March 19, 2020

El Paso County Development Services Department
Attn: Jeff Rice / Steve Kuehster, PCD-Engineering
2880 International Circle
Colorado Springs, CO 80910

**SUBJECT: Comment Response Letter (SF-19-014)
Bent Grass Residential Filing No. 2 Fourth Submittal**

[illegible]

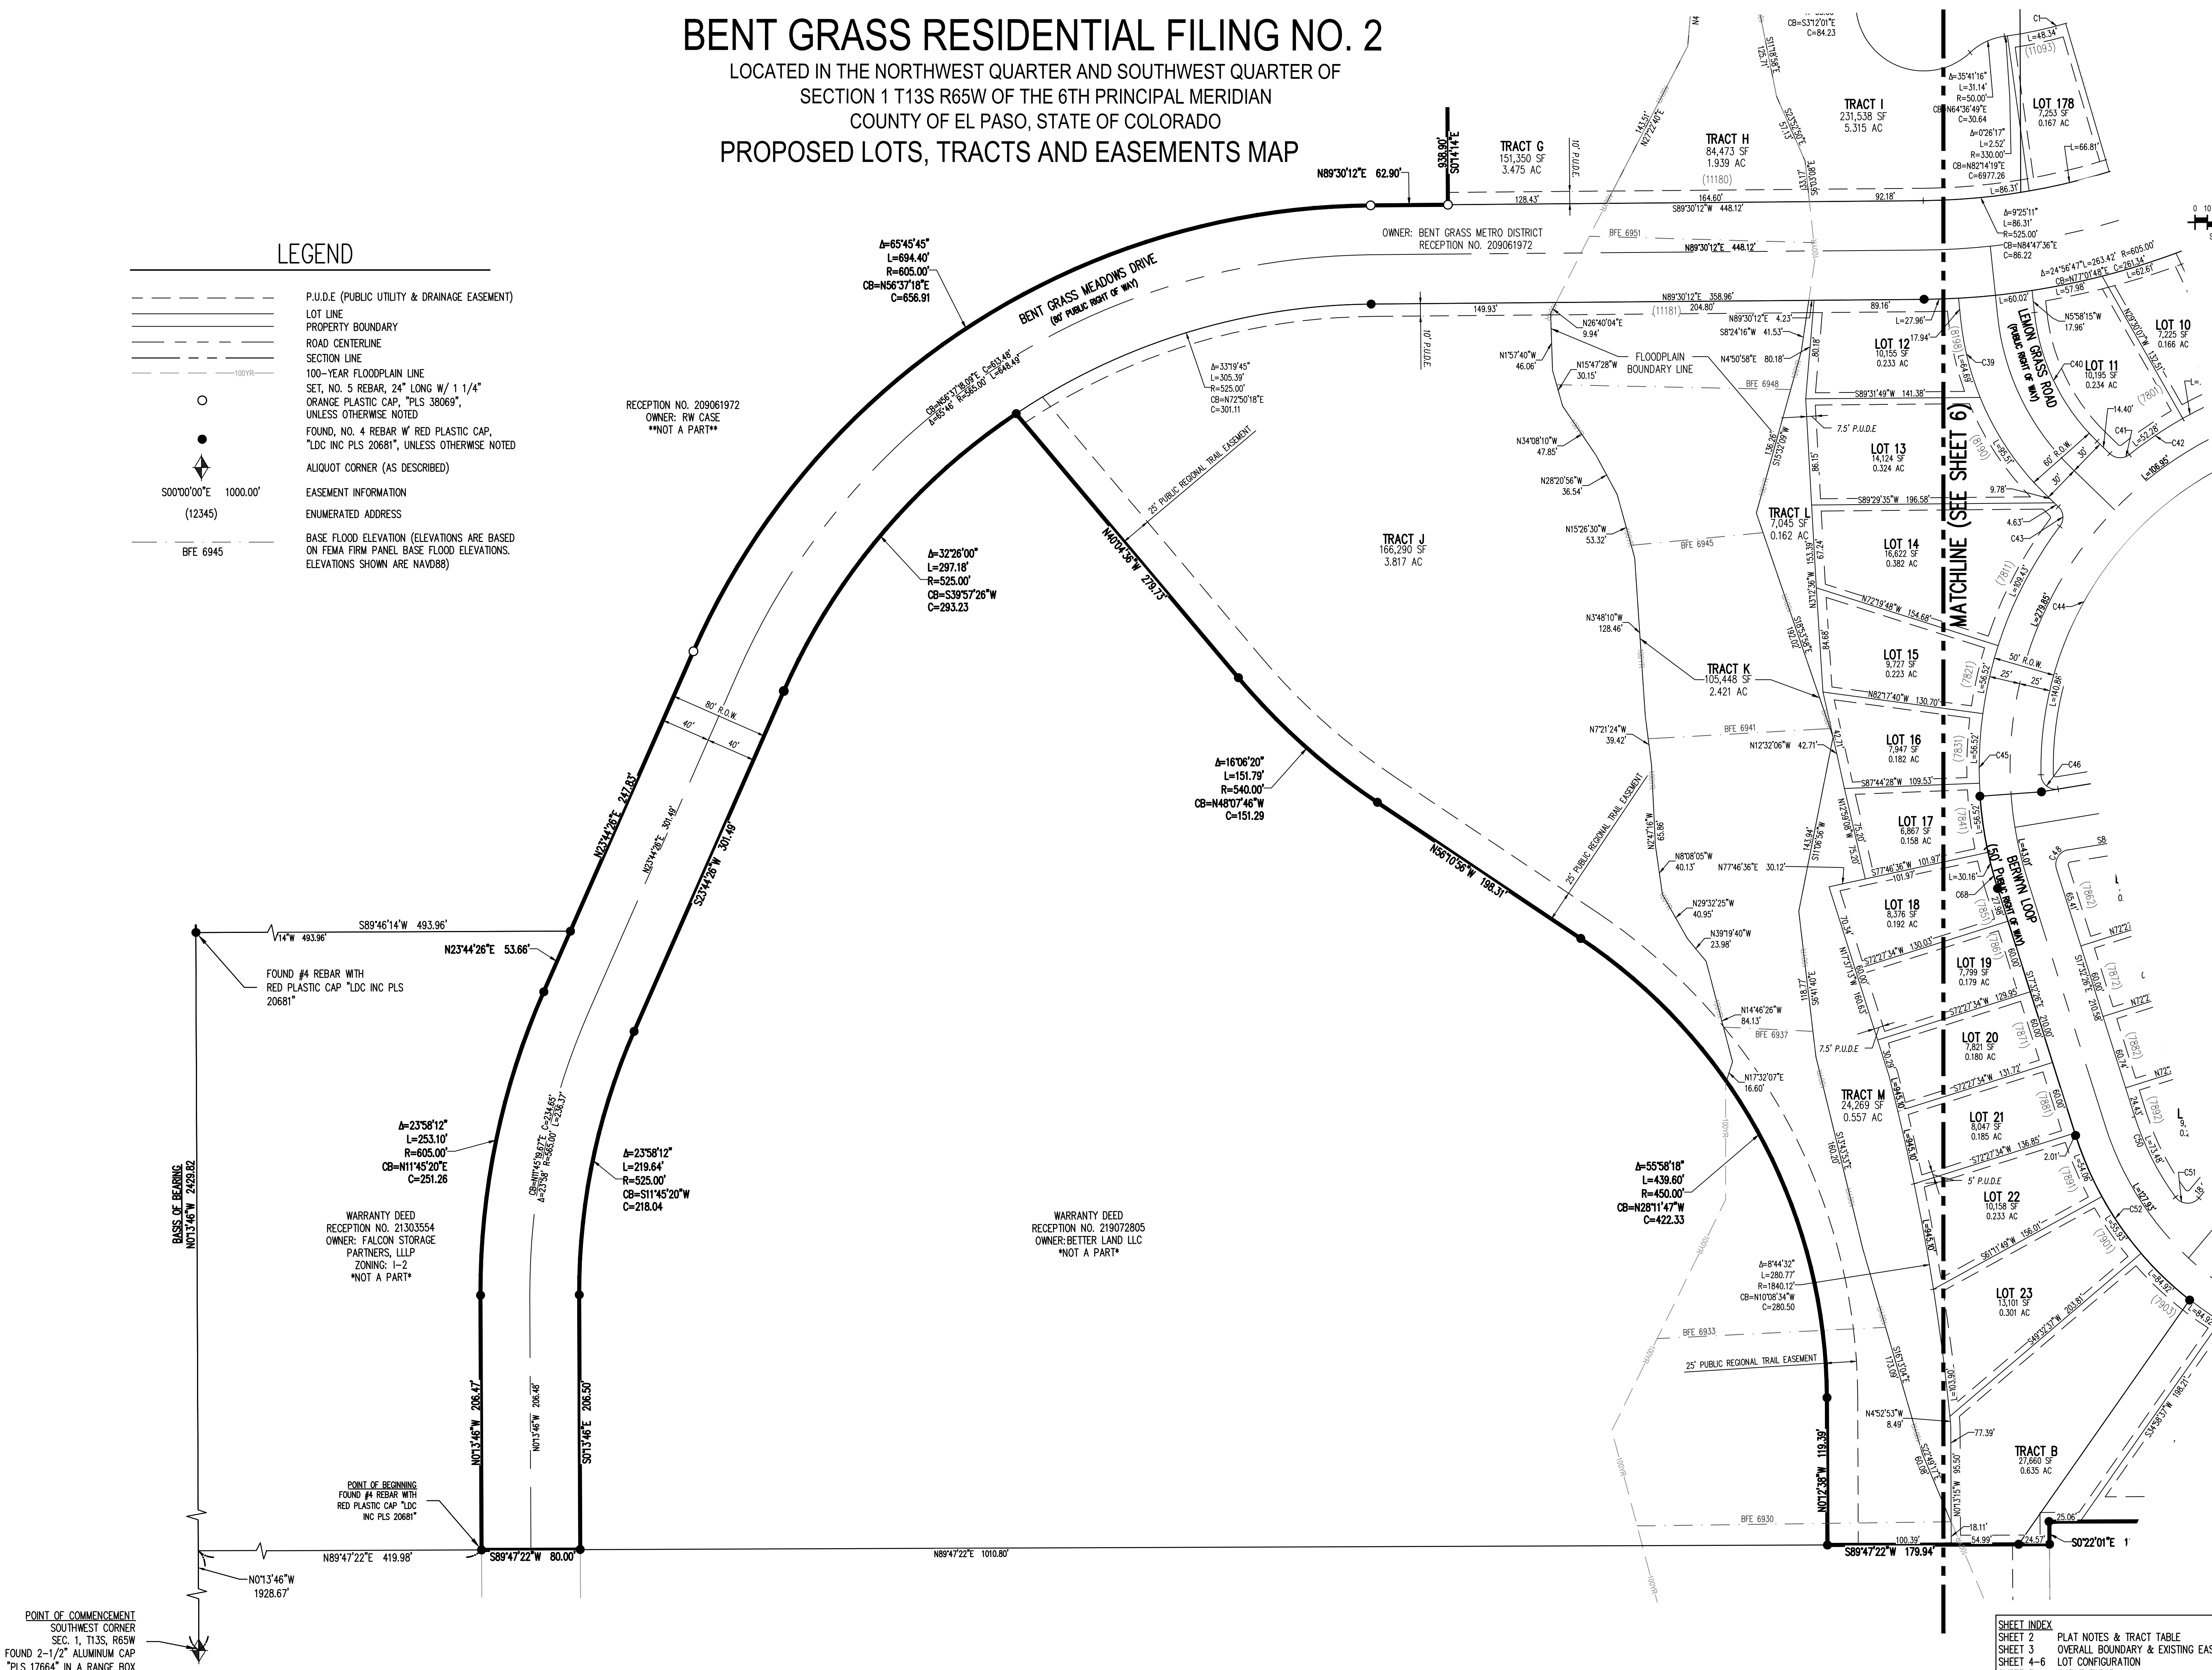
2. **Resolved.**
3. Resolved.
4. Regarding the necessary (redlined) temporary cul-de-sac easements (if not proposed as ROW), the template of the Non-Exclusive Permanent Easement can be provided electronically upon request. Unresolved. **Unresolved. Delete “temporary” from cul-de-sac labels. Provide NEPE form or show the cul-de-sacs with right-of-way which can be vacated and replatted when the roads are extended.**

Response: Removed “temporary” from labels. We are platting as R.O.W. instead of providing NEPE form. We will vacate and replat the extended roads when future filings begin.
